From: Paul Cann
Sent: 05 March 2018 15:04
To: Planning.Responses
Subject: RE: Planning Consultation on BE/22/18/DOC

Condition 5 Surface Water Drainage

APPLICATION NO: **BE/22/18/DOC**

Registered: 22-FEB-18
Site Address: Land West of New Barn Lane Bersted

Ditch Section D-D
Horiz. 1:100
Vert. 1:100

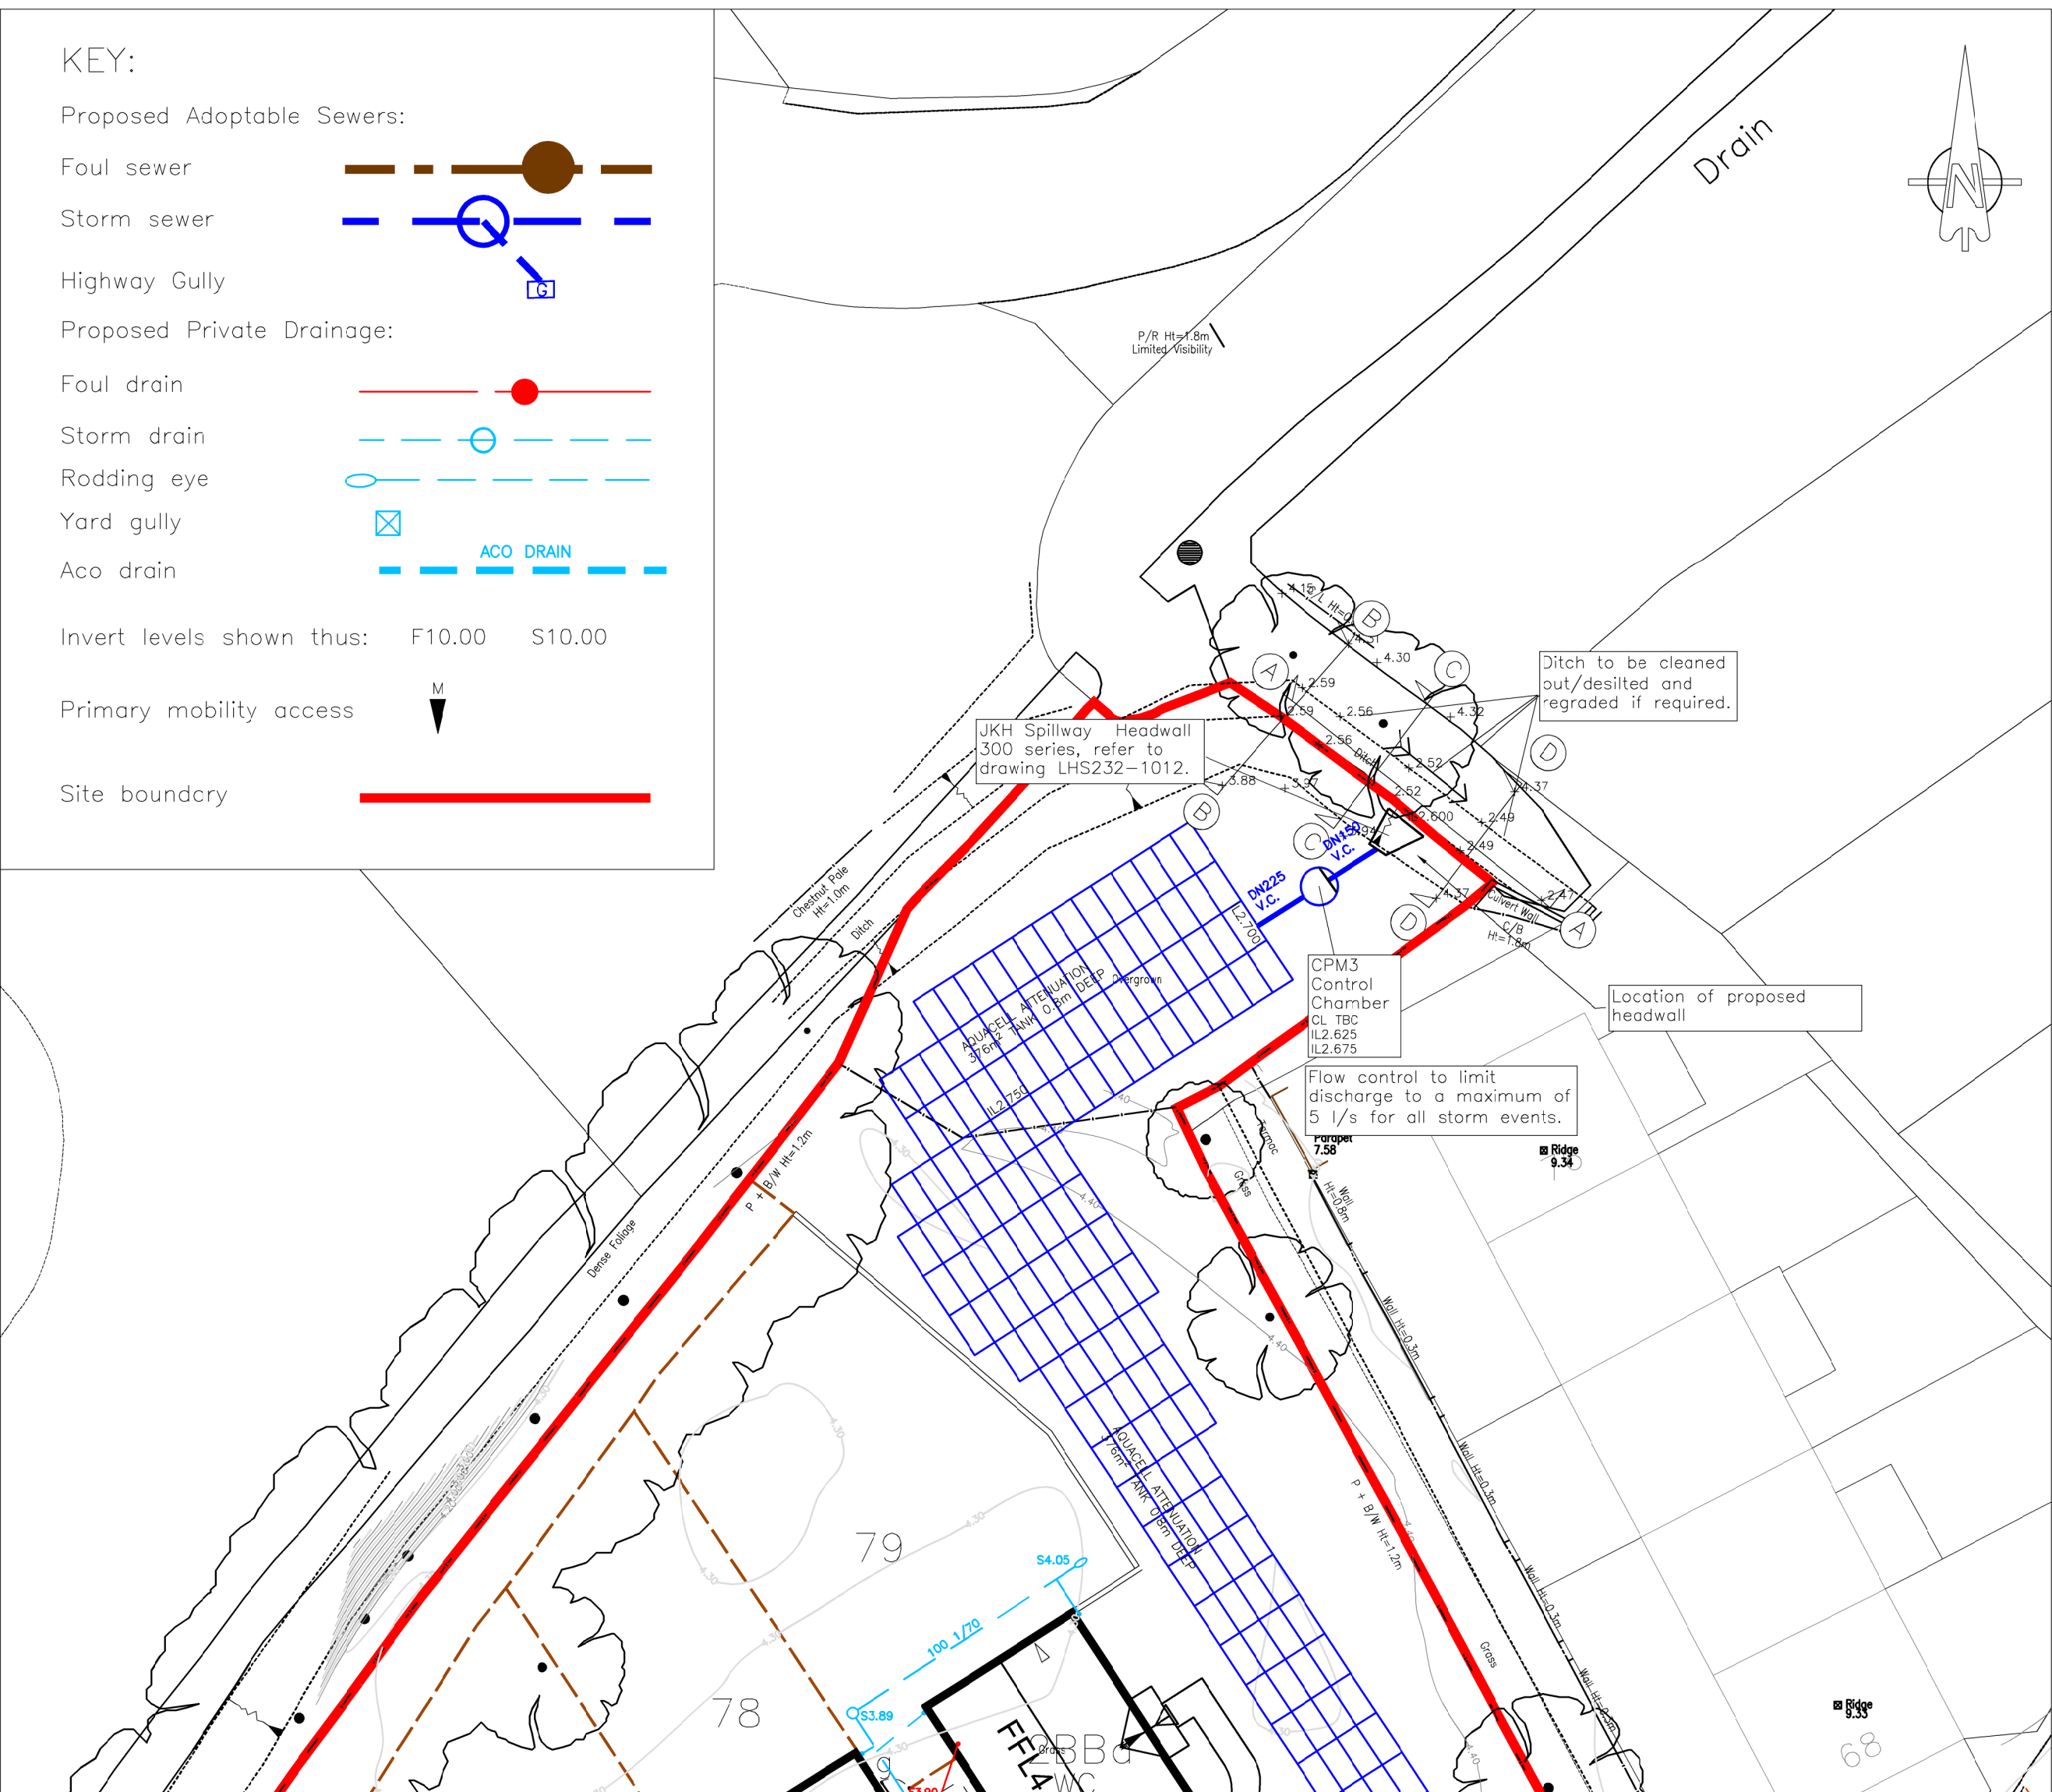
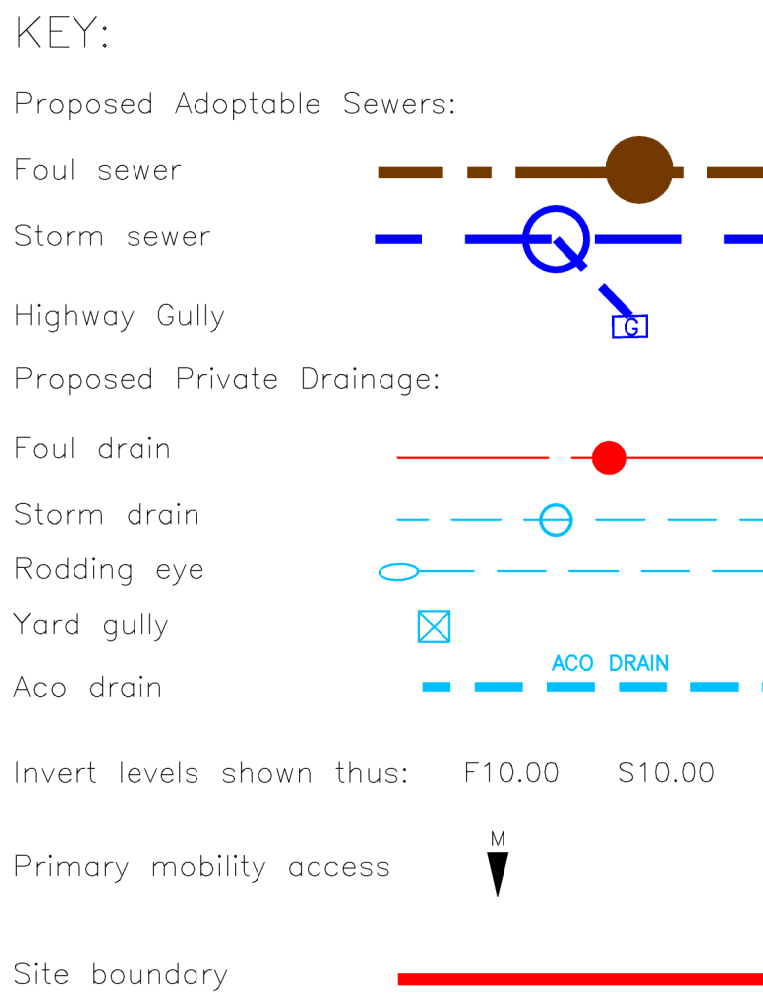
14. Provide headwall details for outfall in NE corner. The structure should not encroach into the ditch profile.
15. Show full pipe details immediately downstream of manhole SW16 on layout plan
